Rezoning Transportation Analysis

Petition Number: 2023-047

From: Jake Carpenter, PE

Date	Description
8-24-23	First Review (IW)

SHEET TITLE:
SCHEMATIC SITE PLAN

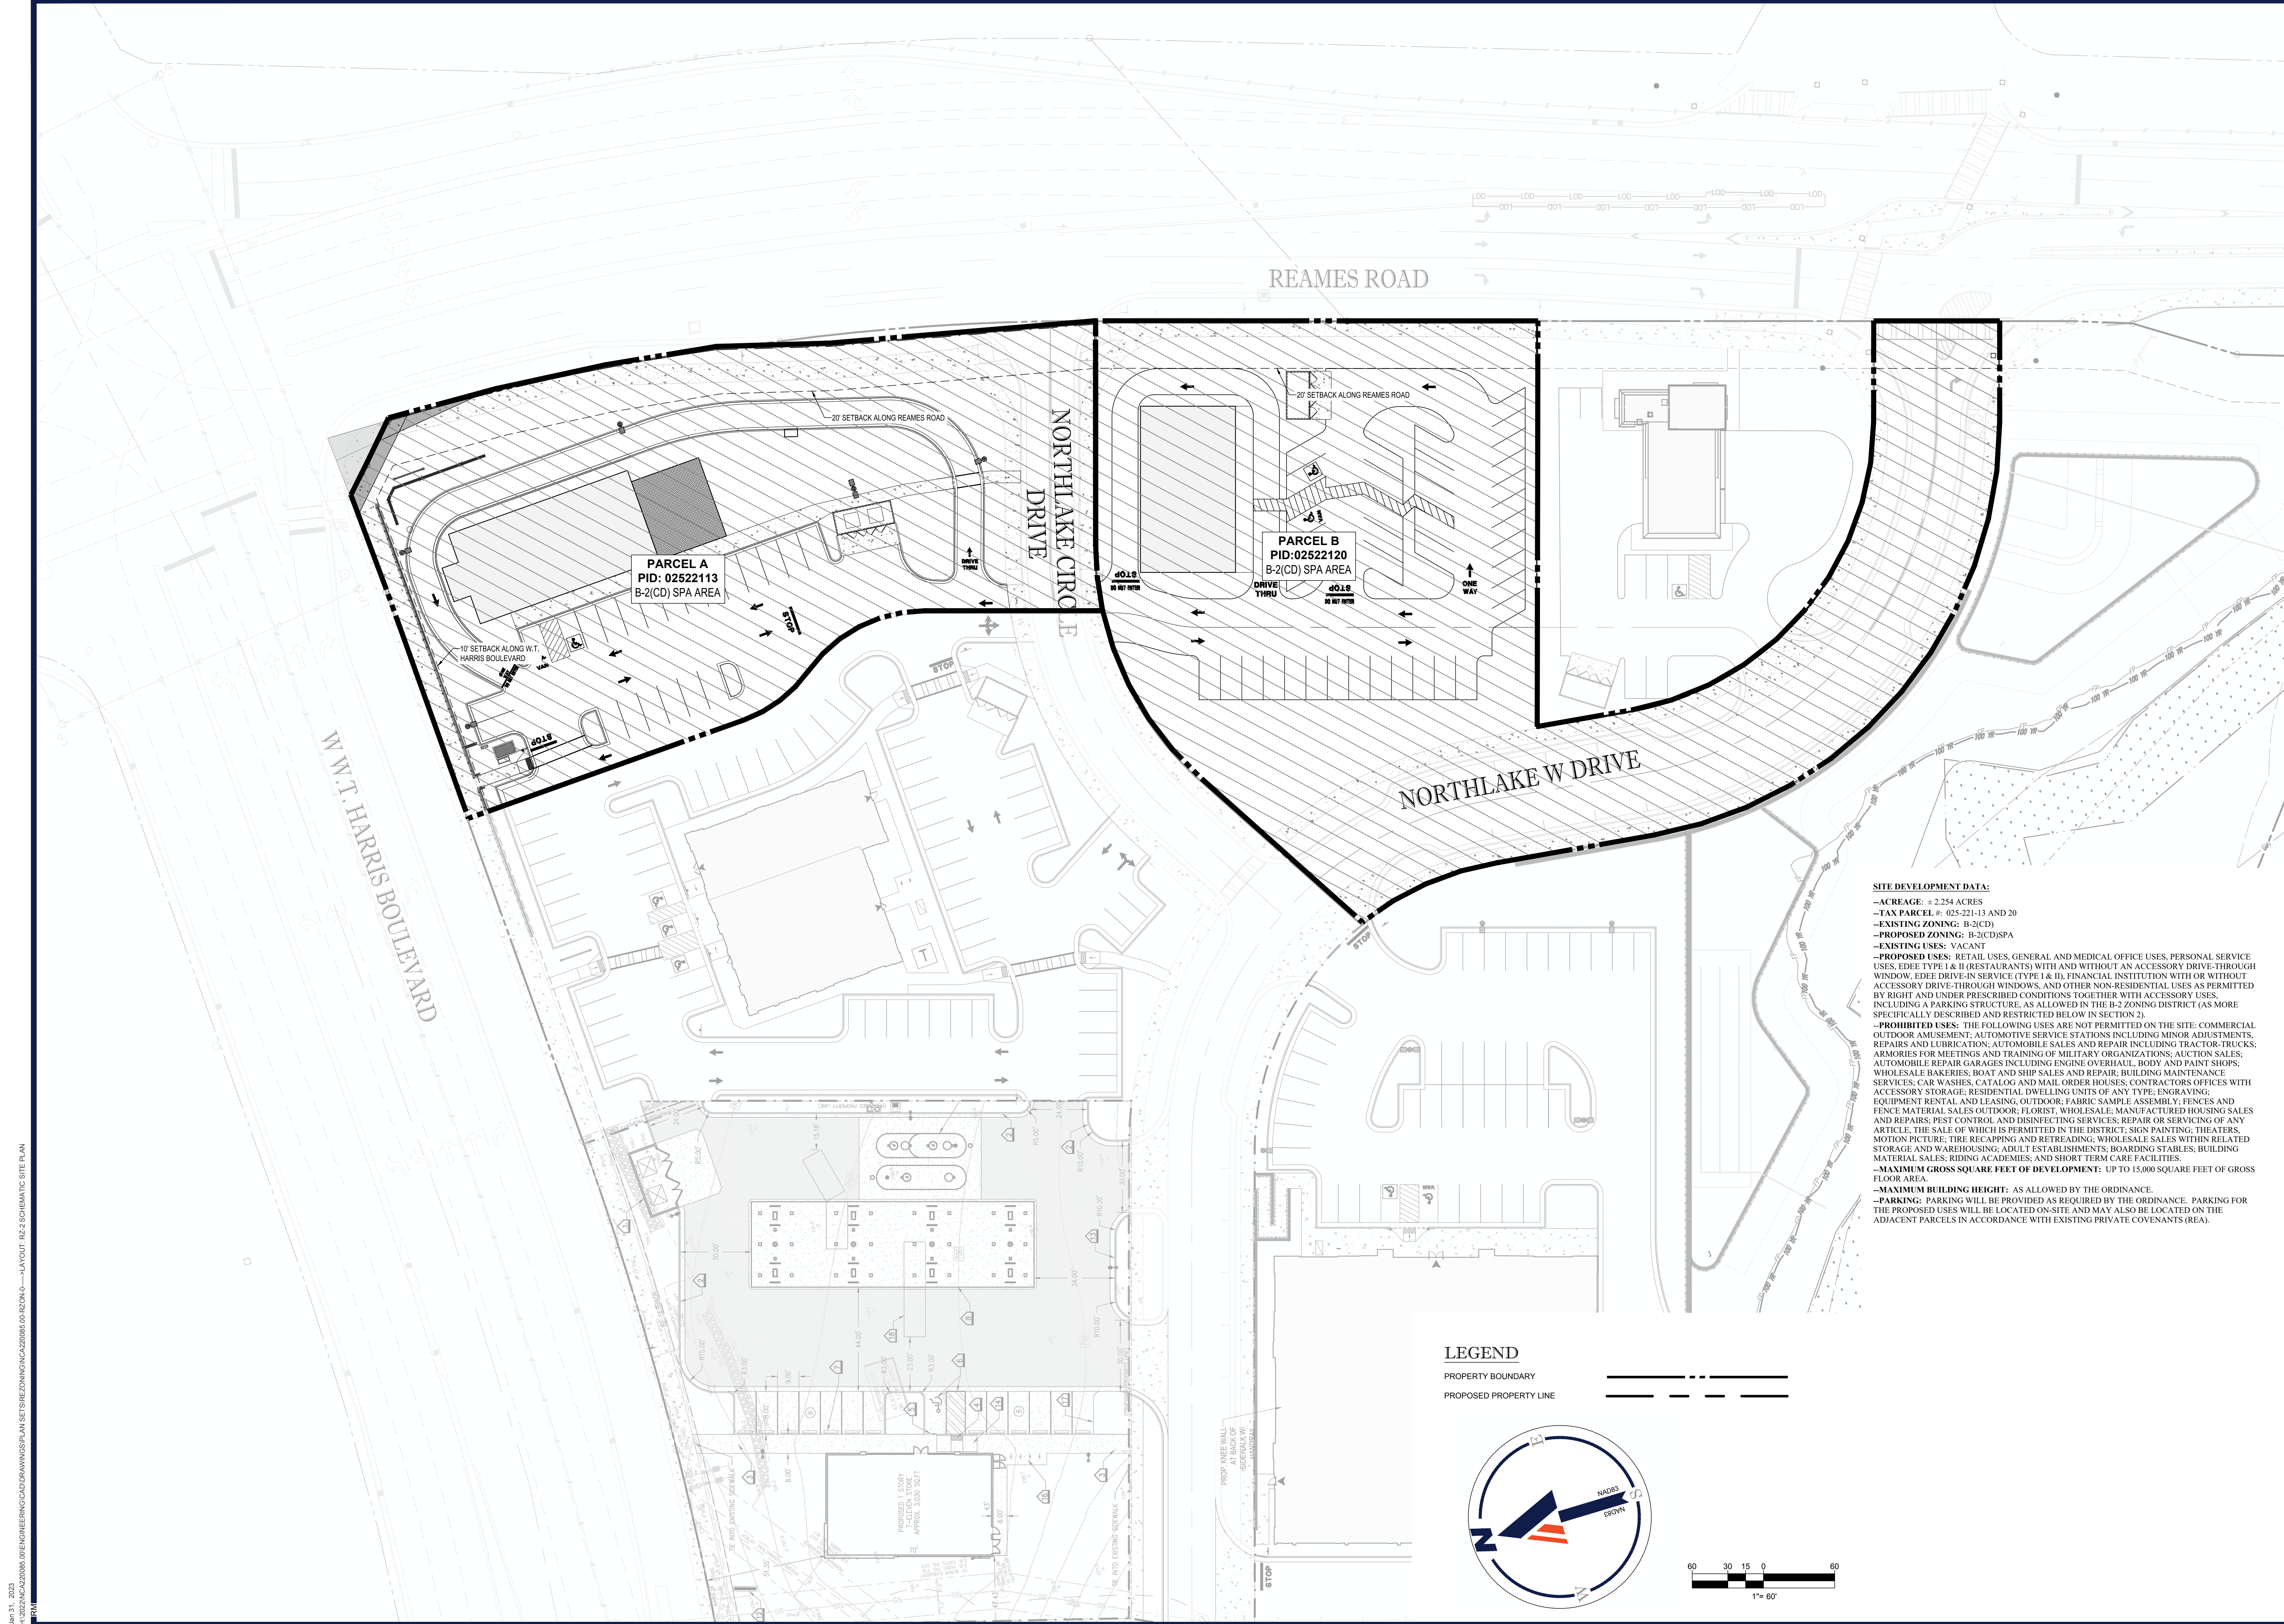
- a. **W T Harris Blvd:** Location of future back of curb and gutter to be 44 feet from roadway centerline to accommodate the Charlotte Streets Map with a roadway typical section of 6+ Boulevard, Shared Use Path.
- b. **Reames Road:** Location of future back of curb and gutter to be moved to 38 feet from roadway centerline to accommodate the Charlotte Streets Map with a roadway typical section of 4+ Avenue, Buffered/Separated Bike Lanes.

Label and dimension the curb and gutter from the centerline for each road on the site plan.

4. CDOT is requesting that the petitioner revise site plan and conditional note(s) to commit to upgrading the construction curb ramps and installing pedestrian signals for the Reames Road and W T Harris Blvd intersection.
